Re: Raising Cane's Restaurant at 1401 Gibson Blvd SE
Erosion and Sediment Control Plan
Engineer's Stamp Date – 8/2/2023 (L15E051A)

Based upon the information provided in your submittal received 8/3/2023, the above referenced ESC Plan can't be approved until the following comments have been addressed.

EROSION CONTROL PLAN PHASE II

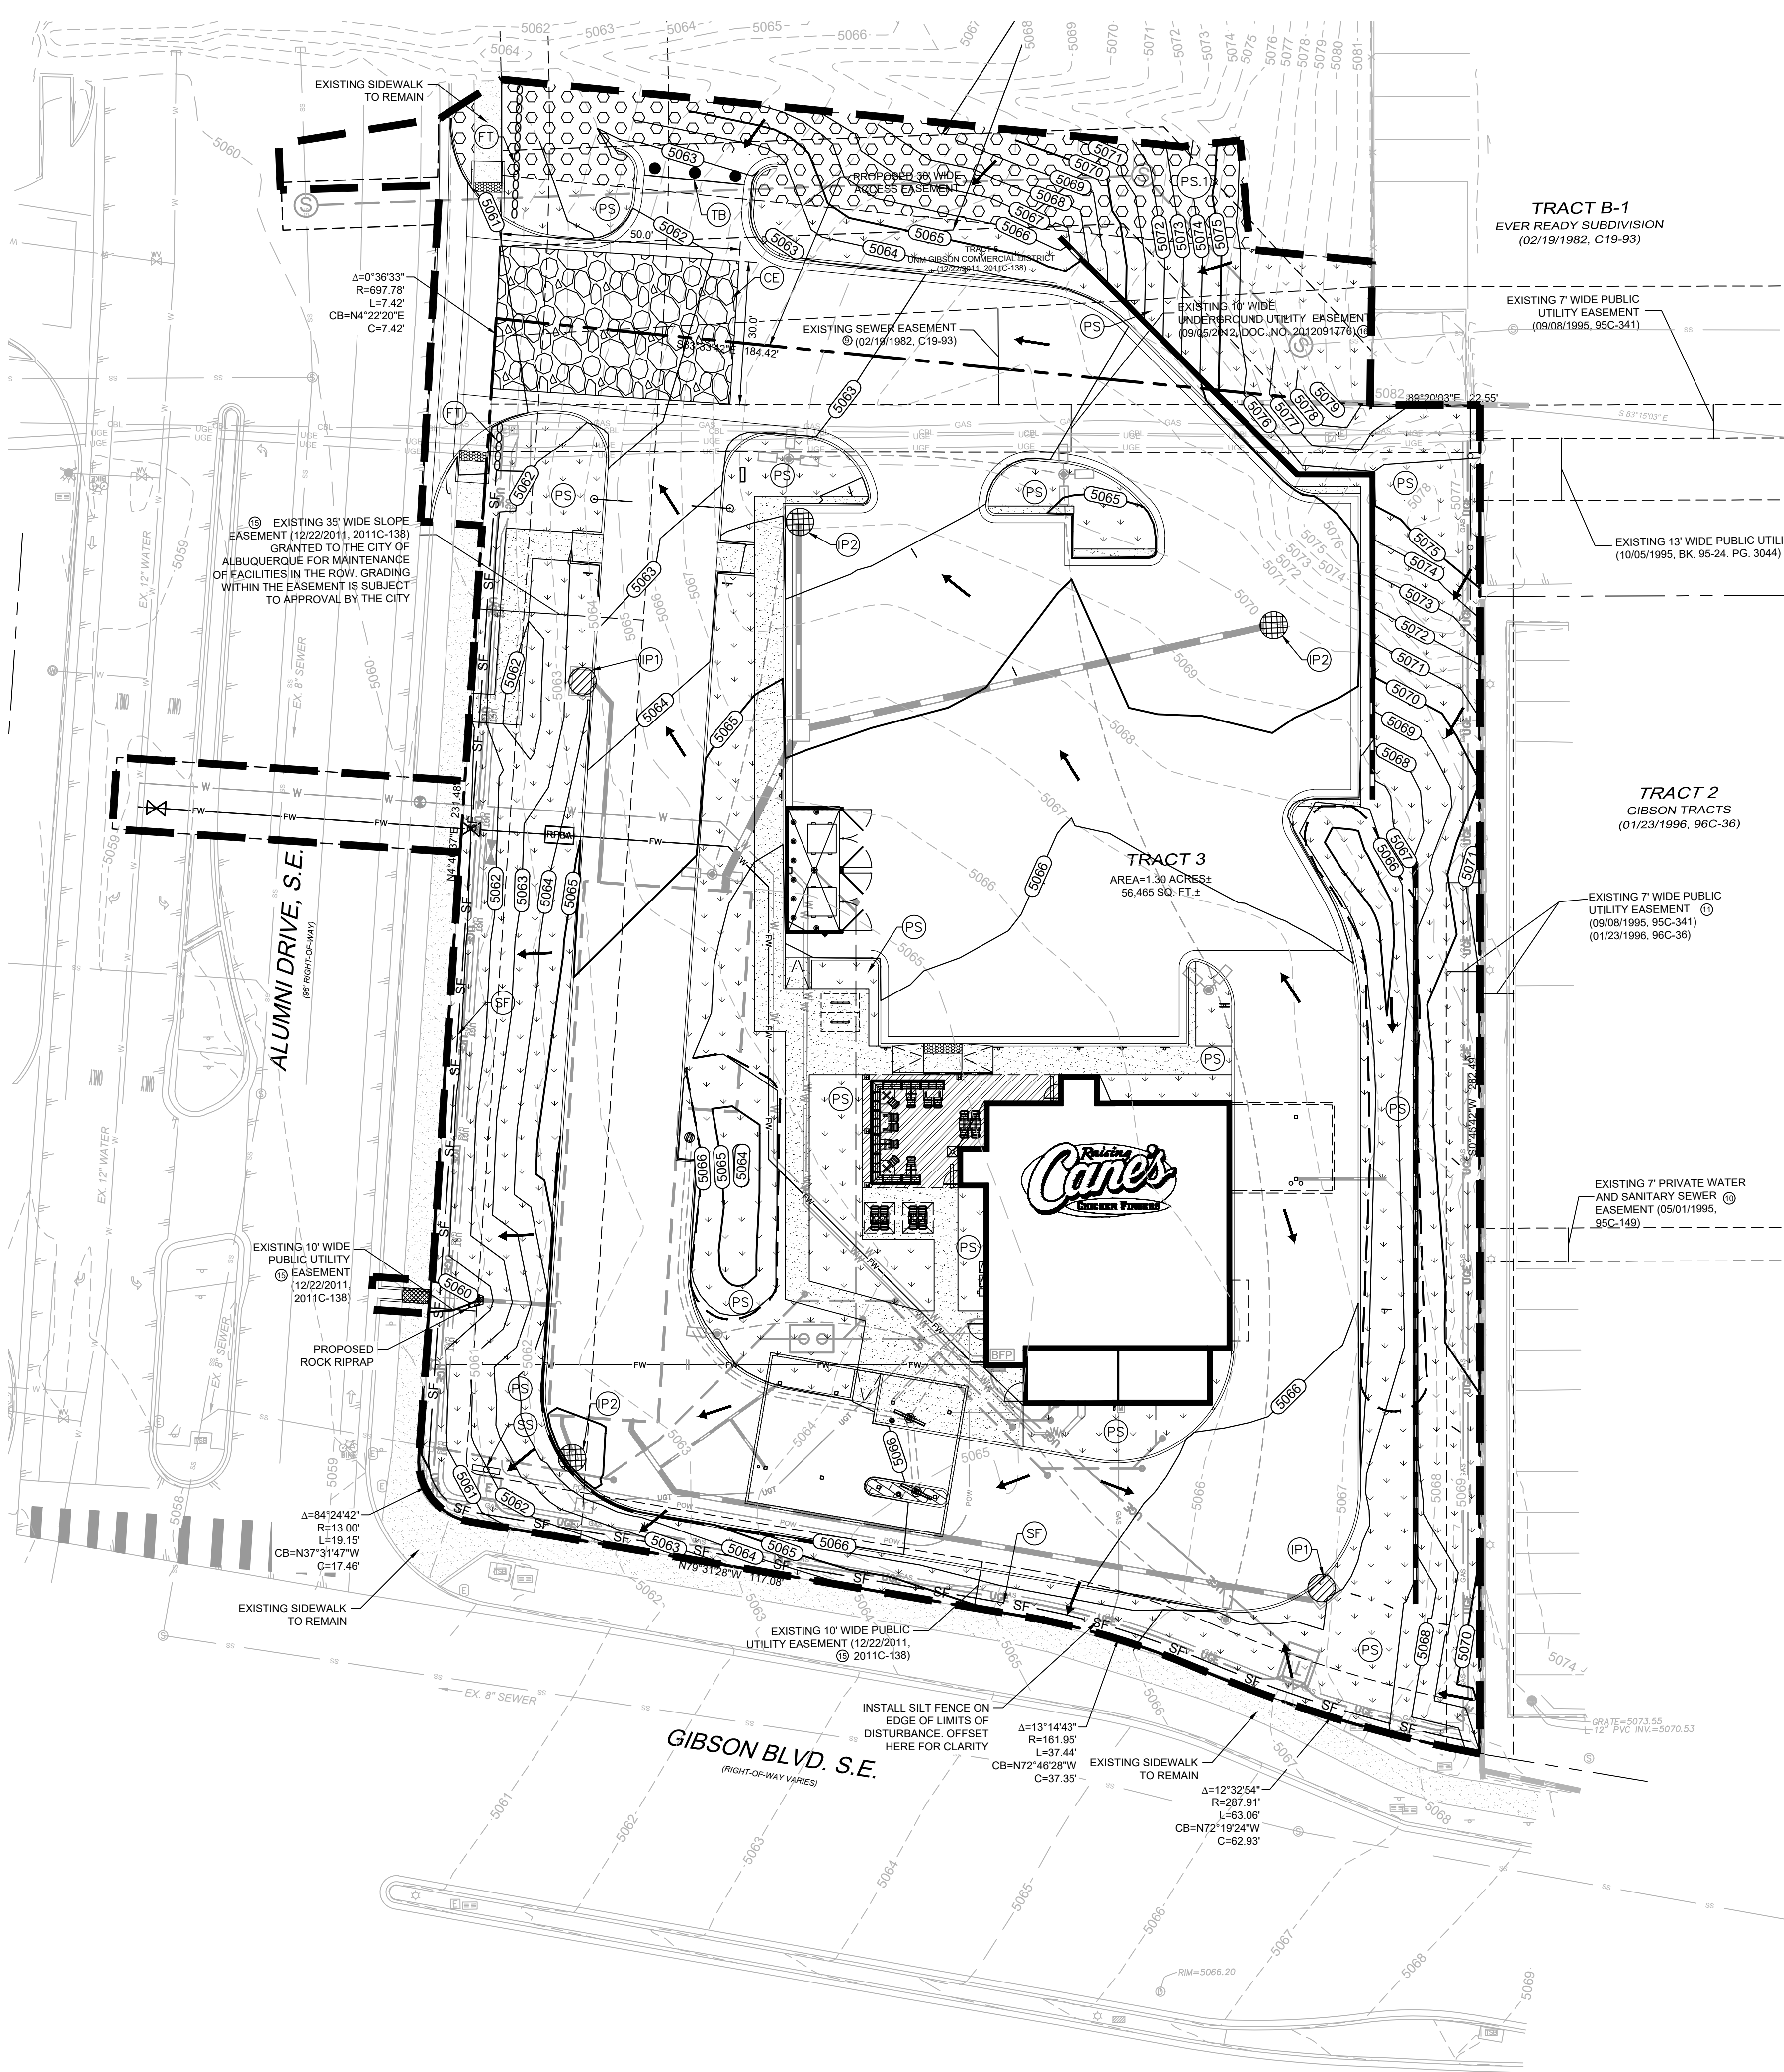
3. After rough grading and throughout most of the construction, a large portion of the site is planned to drain to the northwest corner. Modify phase 2 of the erosion and sediment control plan to prevent uncontrolled runoff from exiting the site through the construction exit after the initial rough grading and until the site paving begins.
